Conversion of the Flint Barn & Garage Barn into 2 No. studio apartments for holiday accommodation for artists. This application may affect the character & appearance of the Angmering Conservation Area.

Glebe Farm Honey Lane Angmering

Thank you for your internet representation made on 4th February 2020 which has been recorded as '**no objection**' with the comments as follows:

drawing
Flint Barn as Proposed
Floor Plan, Roof Plan, Elevations
And Typical Cross Section

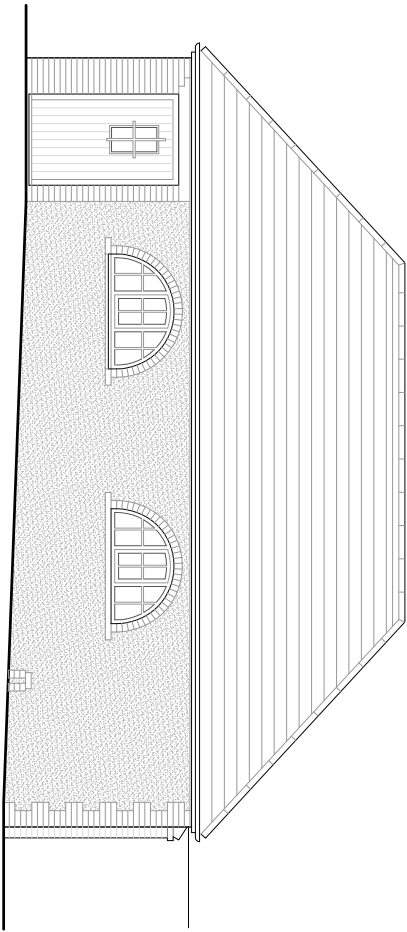
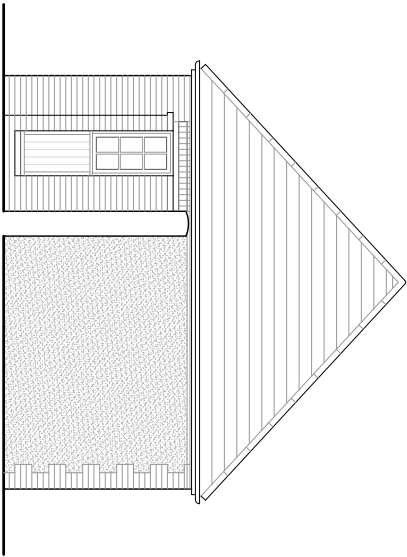
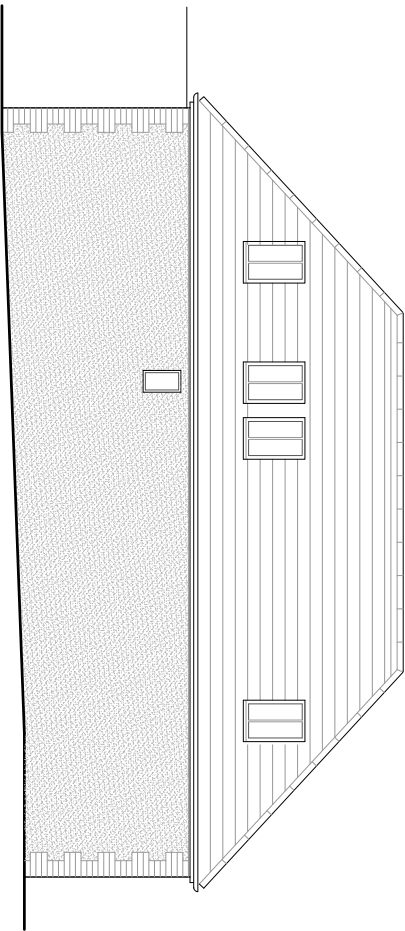
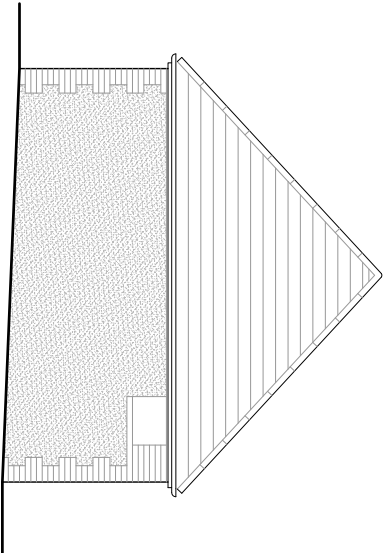
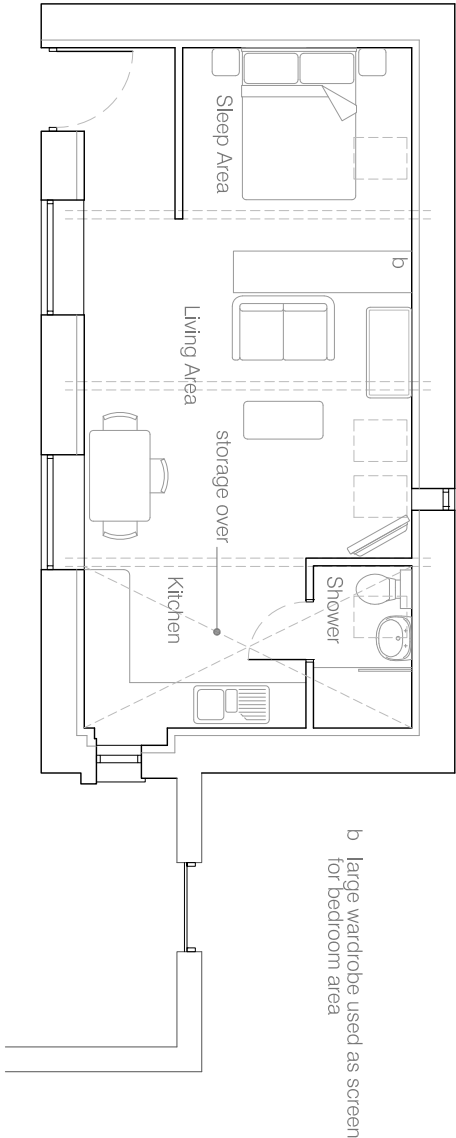
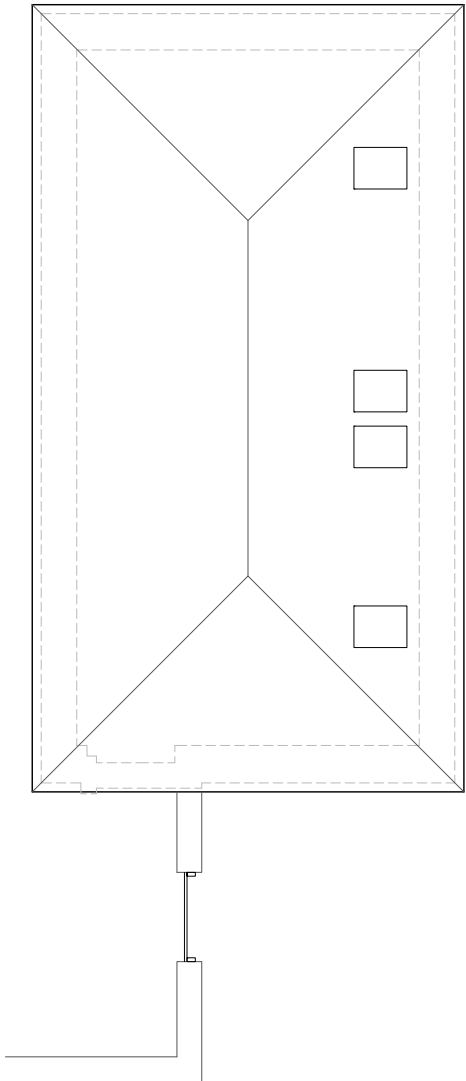
The Panel suggest conditions be attached requiring details of all new joinery. The roof lights should be conservation style.
